**Subject:** Cleve Hill Solar Park EN010085 Ref 20018862

Cleve Hill Solar Park – Soil and agricultural Use Classification– Objections - Addendum Summary

Date: 22/03/2017

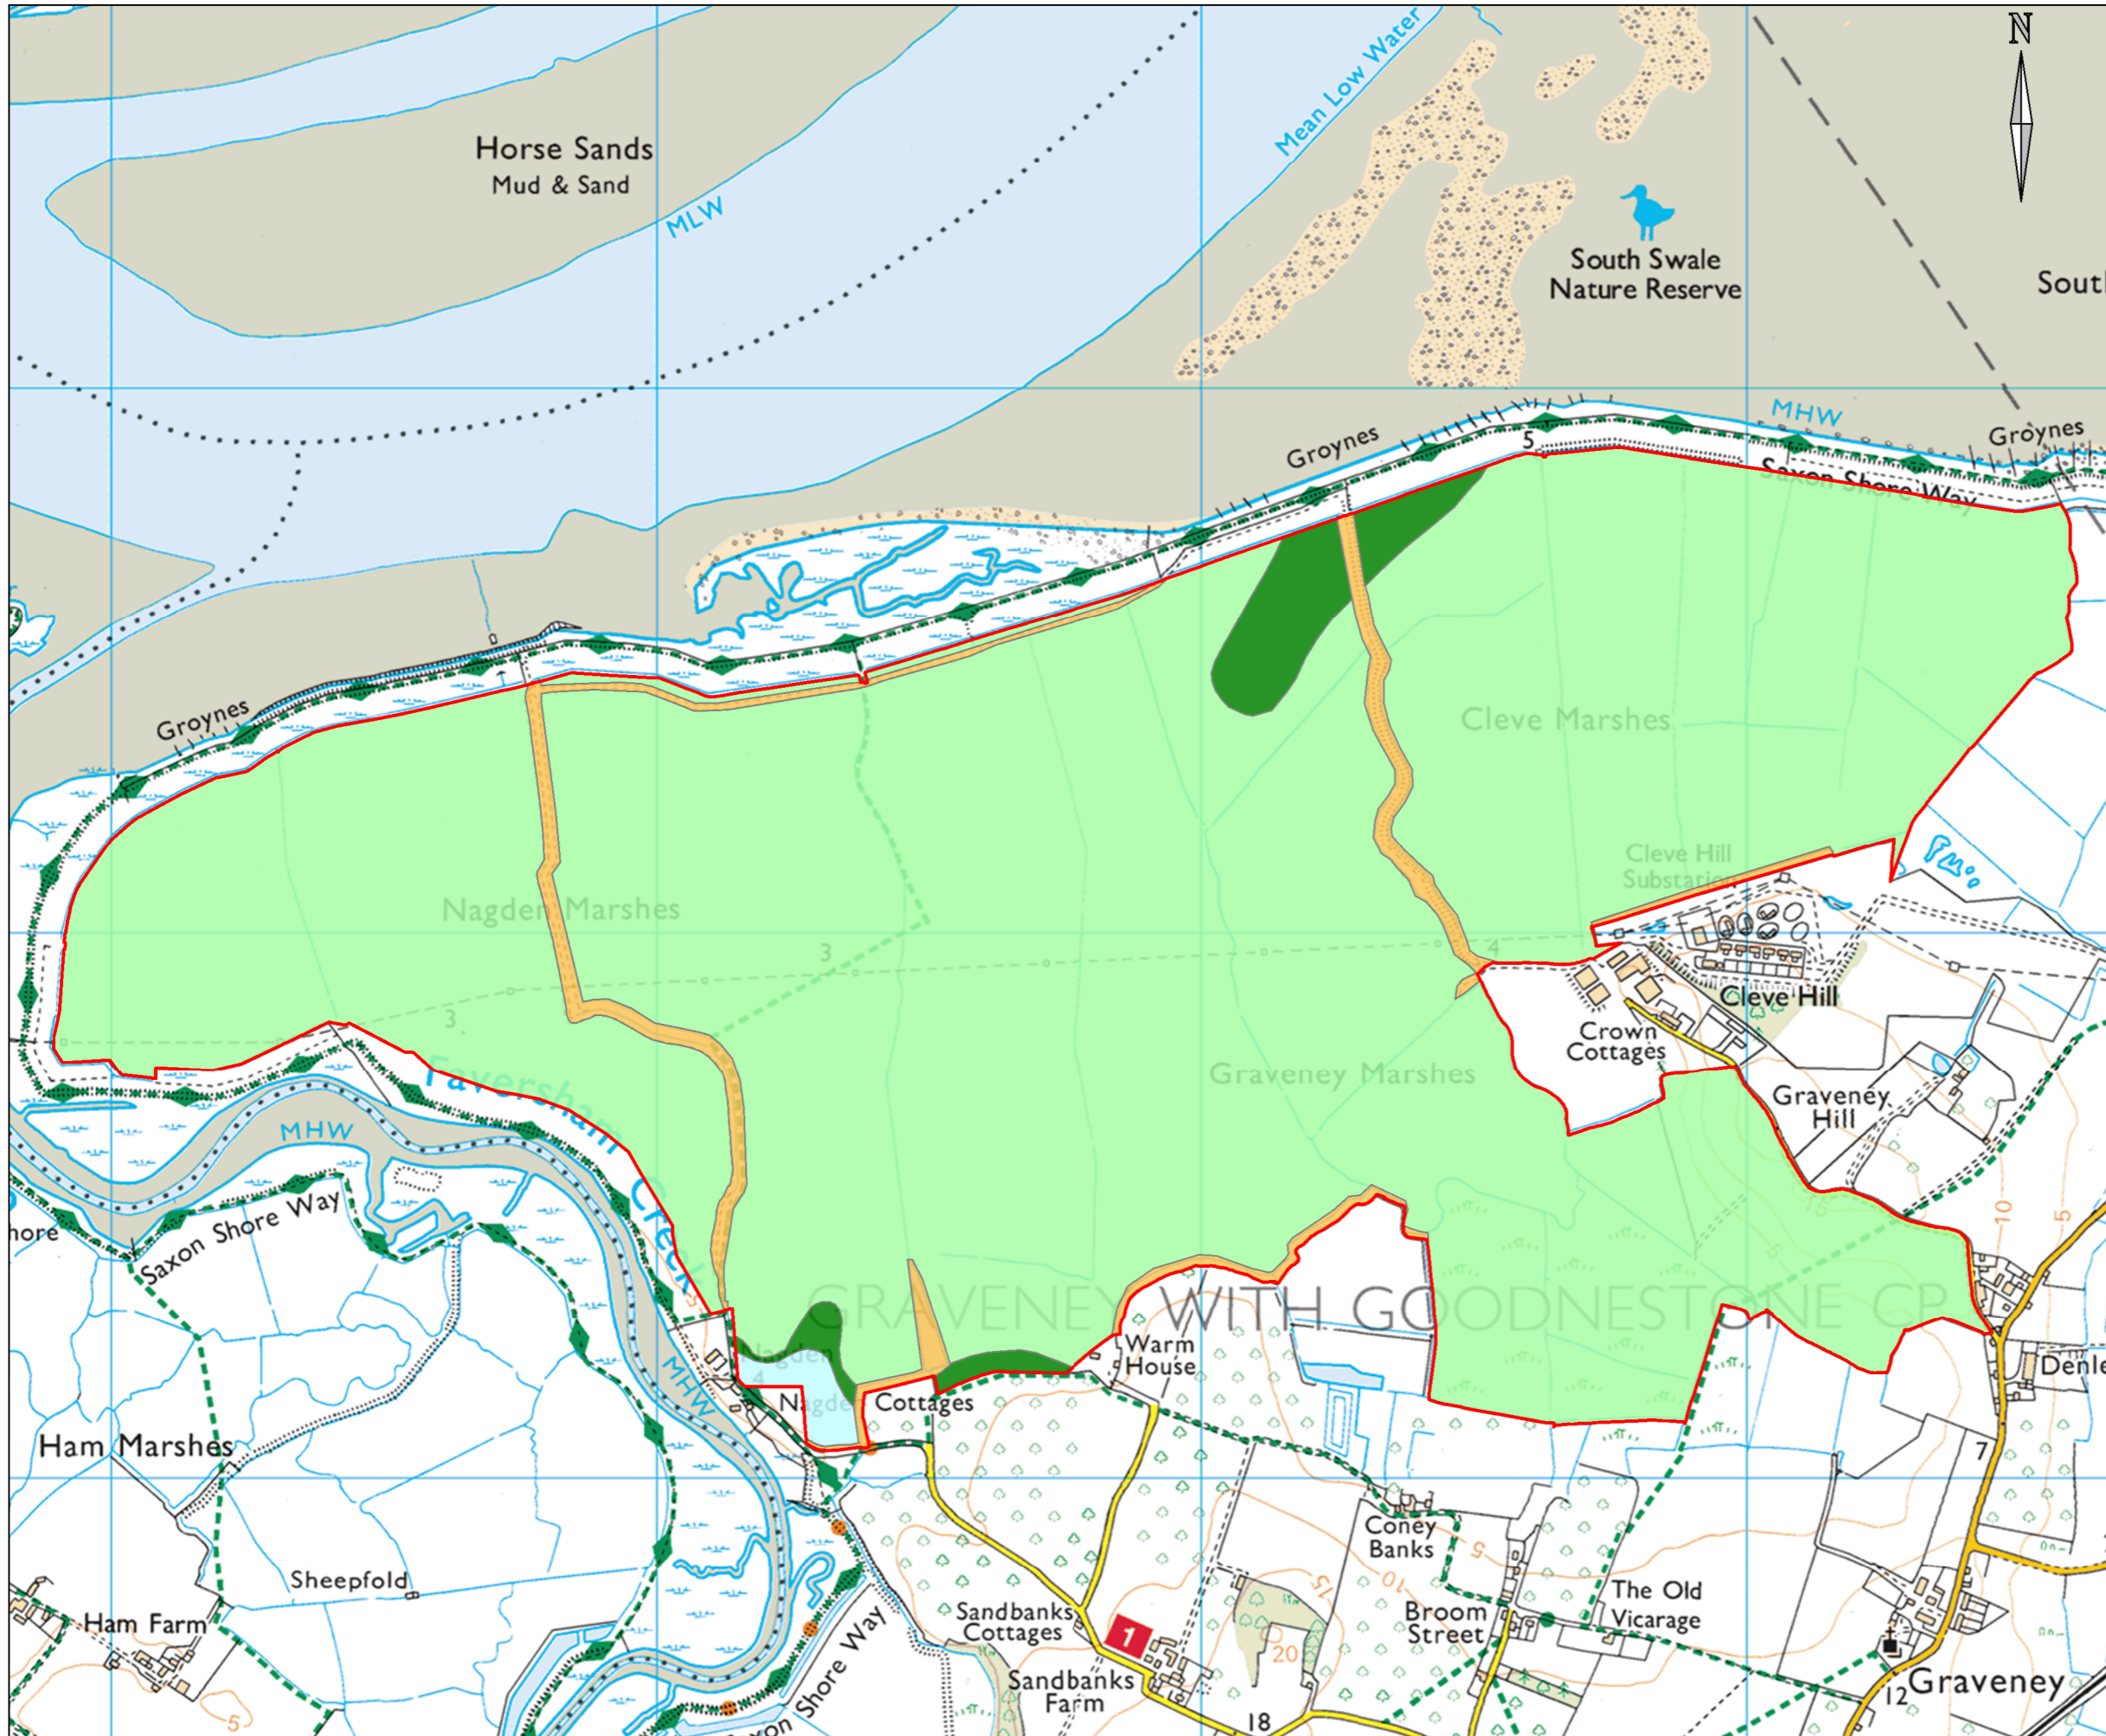
- The Cleve Hill Solar Park SALU 2017 report does not follow and meet the standards of assessment detailed in the ALC MAFF 1988 guidelines;
- The field survey is ‘biased’ in relation to being undertaken at the time of year following an extremely wet February 2017 followed by two weeks of rainfall during the duration of the field survey at the beginning of March 2017;

- Incomplete data has been presented in the report submitted to The Planning Inspectorate;
- Some assessment criteria to determine Wetness Class for two observation locations have been incorrectly interpreted;

- A large number of observation points have been entirely incorrectly interpreted based on the presence of naturally calcareous clay soils;
- No quantitative data (as defined by the MAFF 1988 guidelines) has been presented in the report demonstrating that the soils at the site are water logged for the duration of more than 91-180 days ‘for most years’ i.e Wetness Class III;

- The Soil Survey Handbook 1979, which forms part of the MAFF 1988 guidelines details that single observations at one particular time are speculative and very subjective and also details that soil profiles should not normally be allocated to Class II, III and IV using a single survey at one particular time.

- The gradient of land was identified in the Cleve Hill Solar Park SALUQ 2017 report as a limiting factor, but no actual data was presented to corroborate this statement, and in fact the only

on-site data presented in the Cleve Hill Solar Park SALUQ 2017 report and compared to MAFF 1998 guideline indicates that land with slopes less than 7° are considered Grade 1, Grade 2 or Subgrade 3a land.

- Re-evaluation of the Wetness Class across the site, based on actual and local metrological data and considering that a large part of the land has naturally calcareous soils, it is my opinion that over 75% of the land at Cleve Hill Farm can be graded as Grade 2 (very good agricultural land) and Subgrade 3a (good agricultural land) in accordance with MAFF 1988 guidelines.
